# M42 Junction 6 Development Consent Order

## **8.8(a) Statement of Common Ground with Solihull Metropolitan Borough Council**

**STATEMENT OF COMMON GROUND  
Solihull Metropolitan Borough Council**

Drawing Title  
**REVISED ACCESS ARRANGEMENTS FOR FOUR WINDS AND GAA**

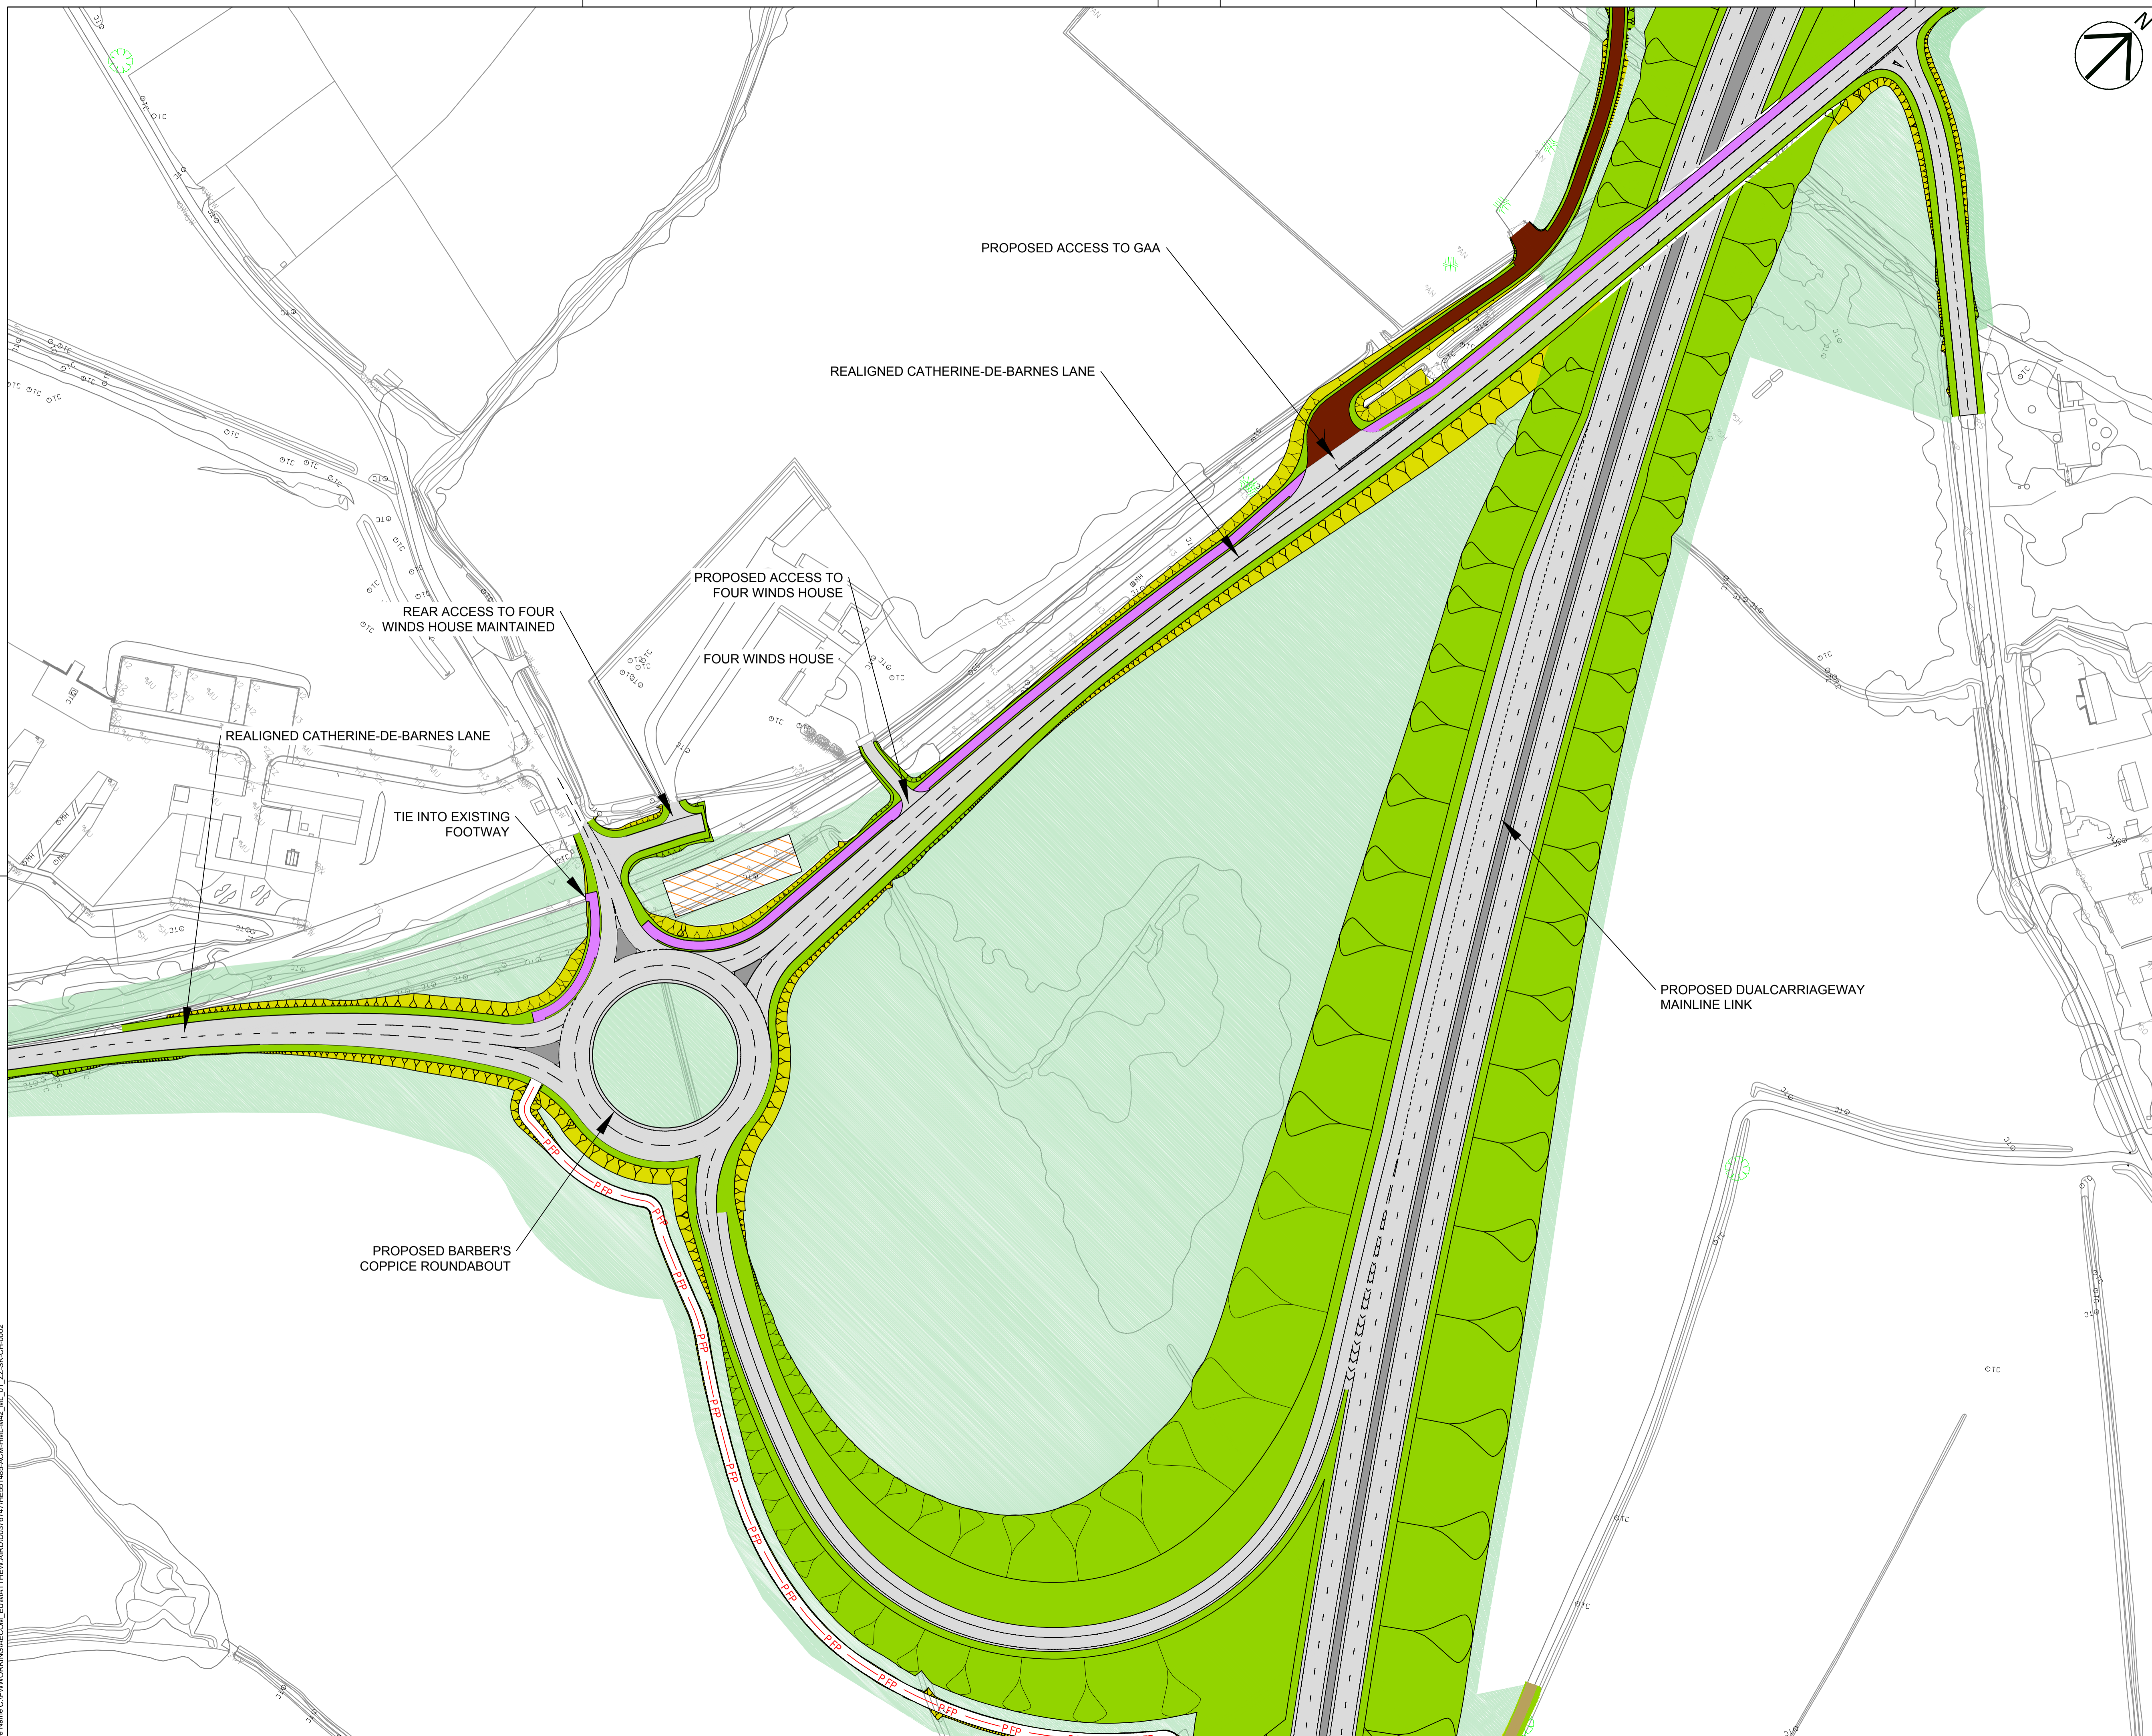
| Sub-topic                                     | SMBC Comment  | Highways England Response/Actions   | Status/Agreement                |
|---|---|---|---------------------------------|
|   | <p>An alternative access is welcomed.<br/>Is there an alternative access to the WGAA, off Catherine-de-Barnes Lane, that would avoid a link past Four Winds?</p>                              | <p><i>Highways England has developed a proposal for an alternative access for the WGAA within the Order Limits that has been discussed with SMBC. It was noted that this proposal is preferable to SMBC.</i><br/><br/><i>Highways England will be putting this forward to the ExA as part of the more detailed proposals for the WGAA reconfiguration.</i></p>  | <p>Agreed</p>                   |
